# CITY OF ALBUQUERQUE

March 14, 2016

**Re: APS Career Enrichment Center  
807 Mountain Rd. NE  
Requested for Permanent C. O. - Accepted  
Engineers Stamp Date 12/3/14 (J15D001)  
Certification dated: 3-11-16**

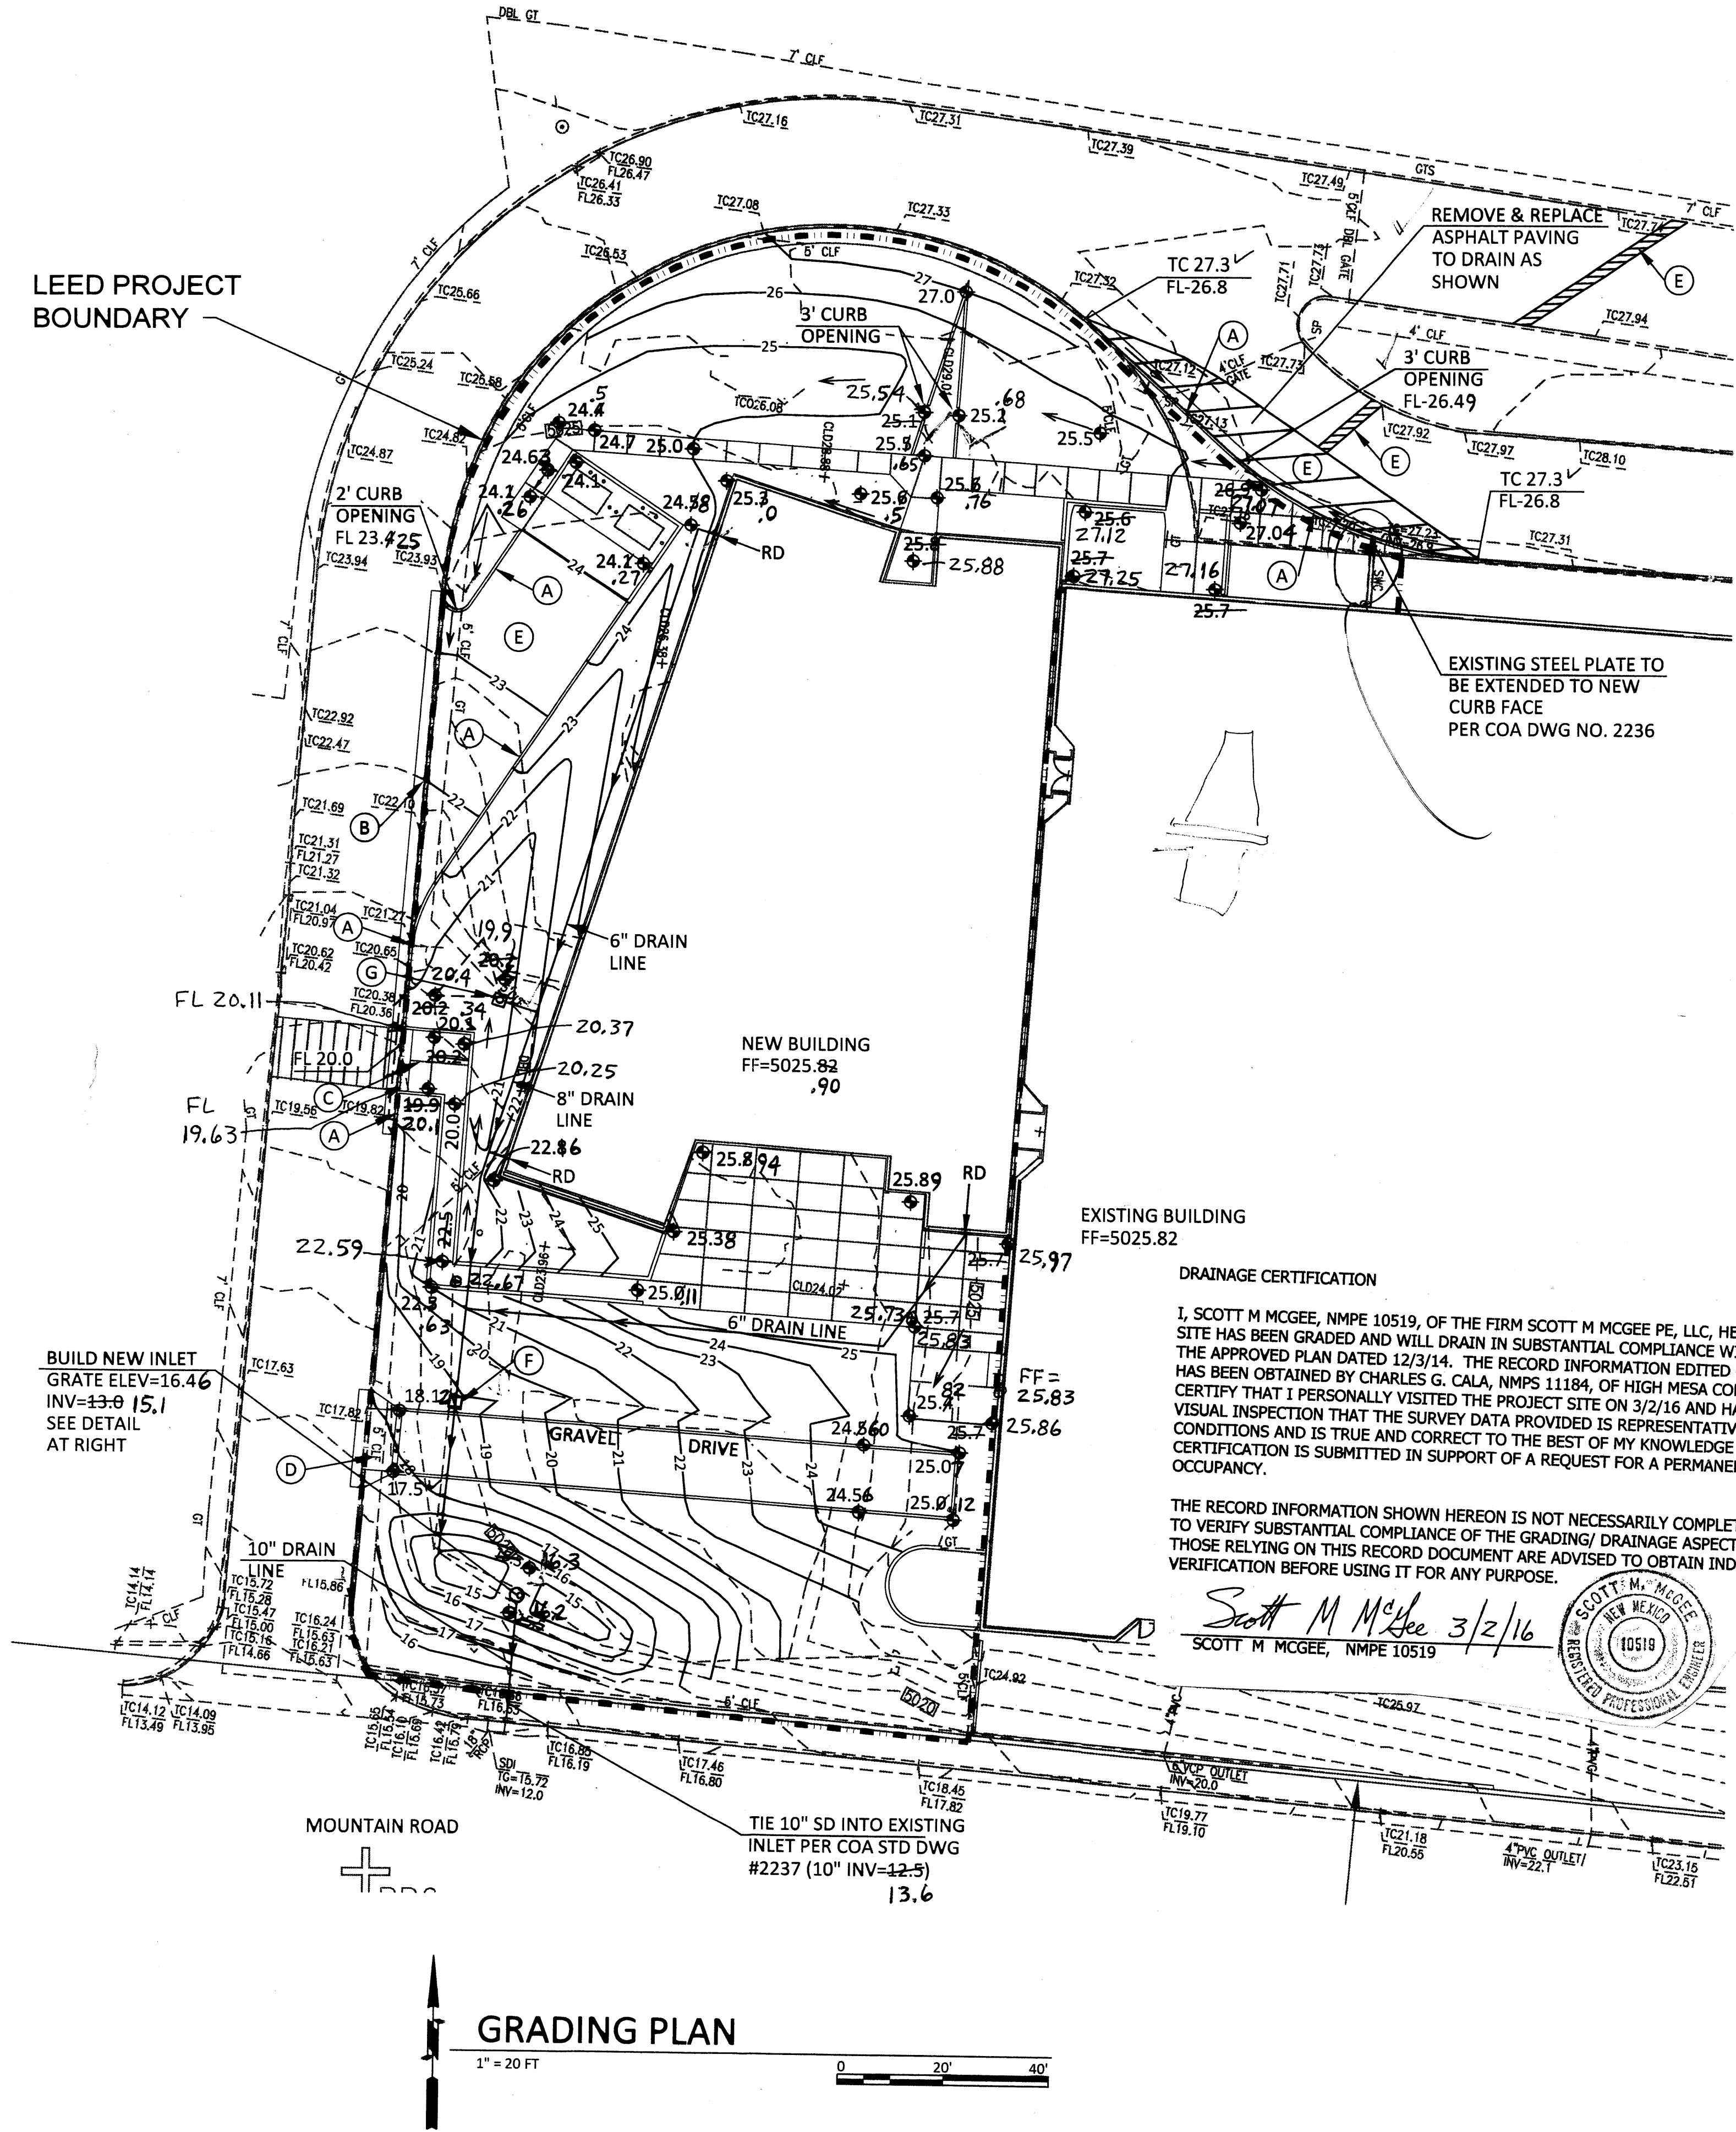
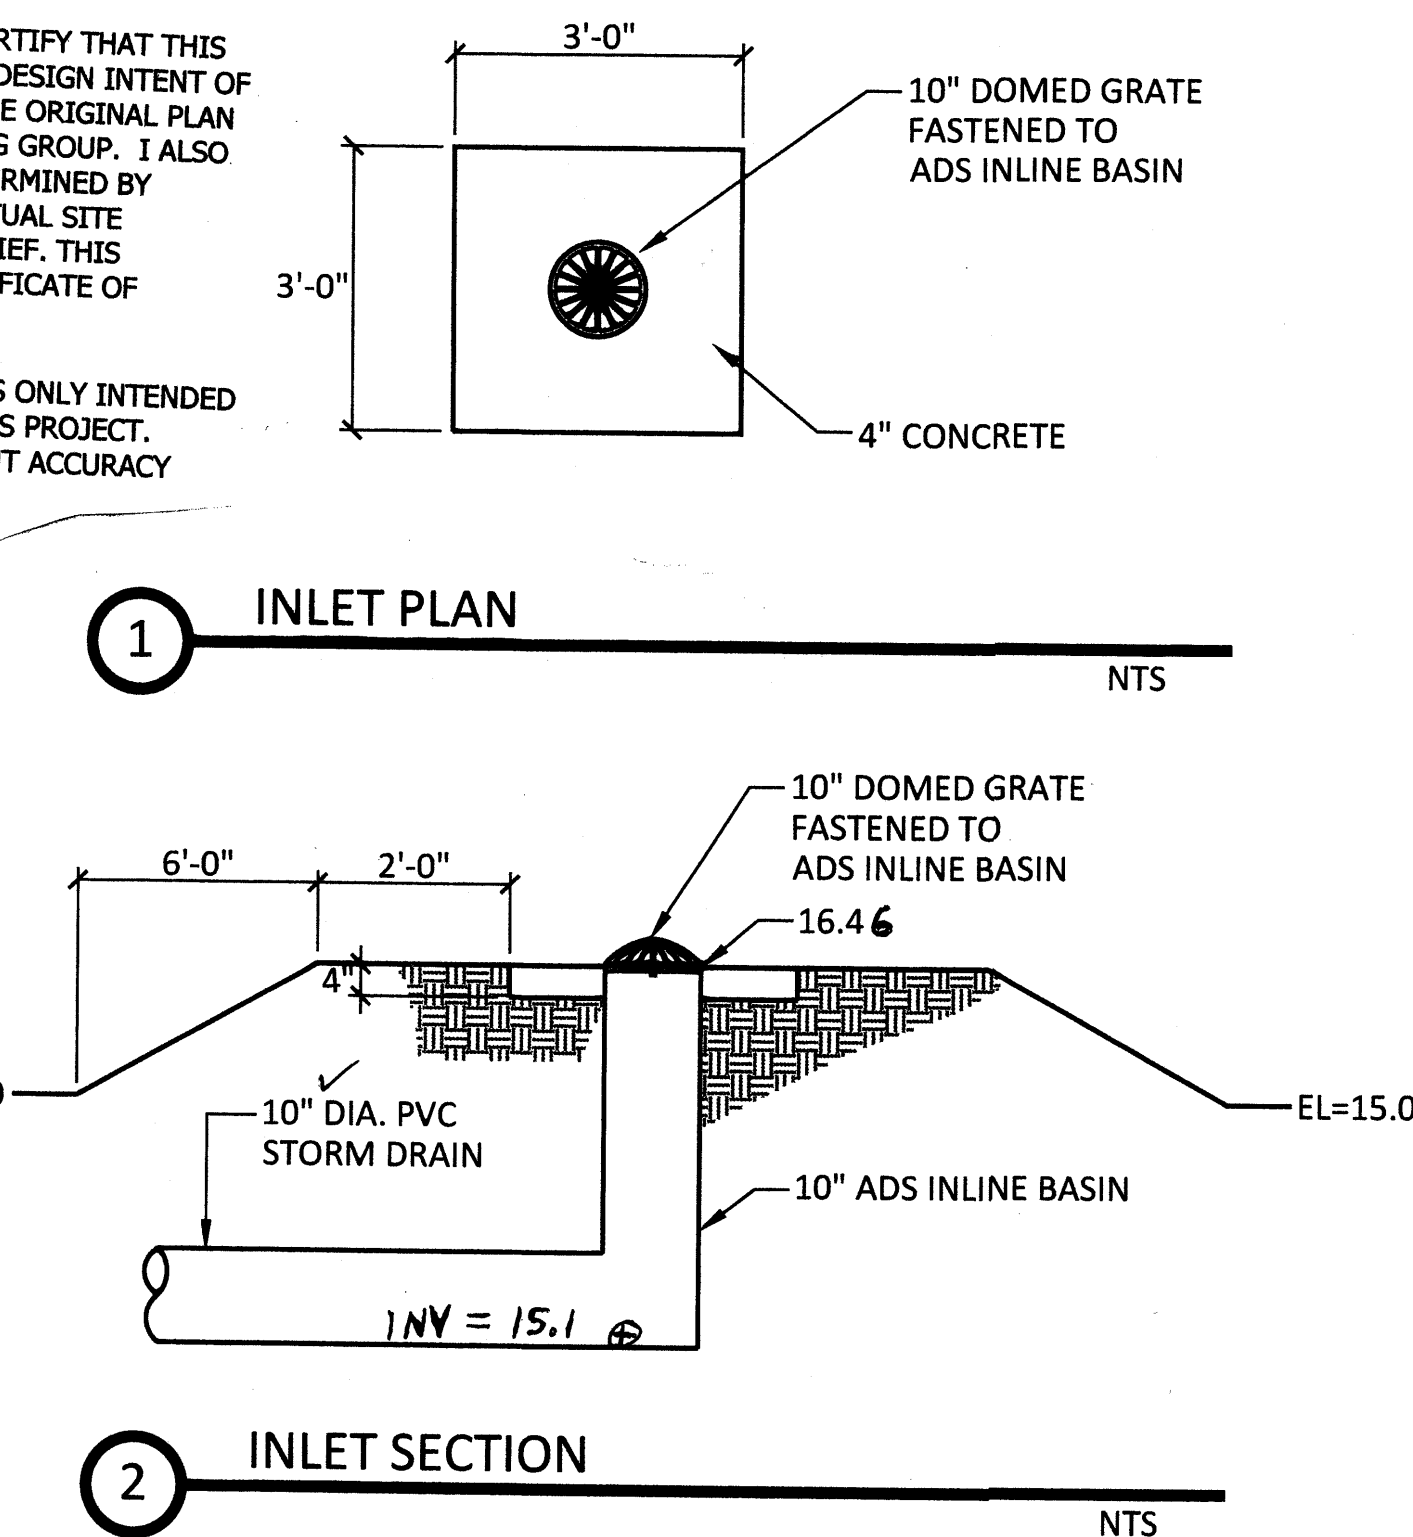
- On the north side of the building the existing steel plate has not been extended to the new curb face.
- On the drawings there is a roof drain called out on the south side of the building. That area is behind a locked enclosed area and I was unable to verify the roof drain.
- There is an existing manhole south of the new pond with the cover tipped up presenting a hazard.

1. The Contractor has installed the steel plate extension where the sidewalk was widened on the north side of the existing building.
2. The Contractor is available onsite to allow you access to the fenced off area to confirm the roof drain location.
3. The Contractor has addressed the valve box cover identified as a hazard.
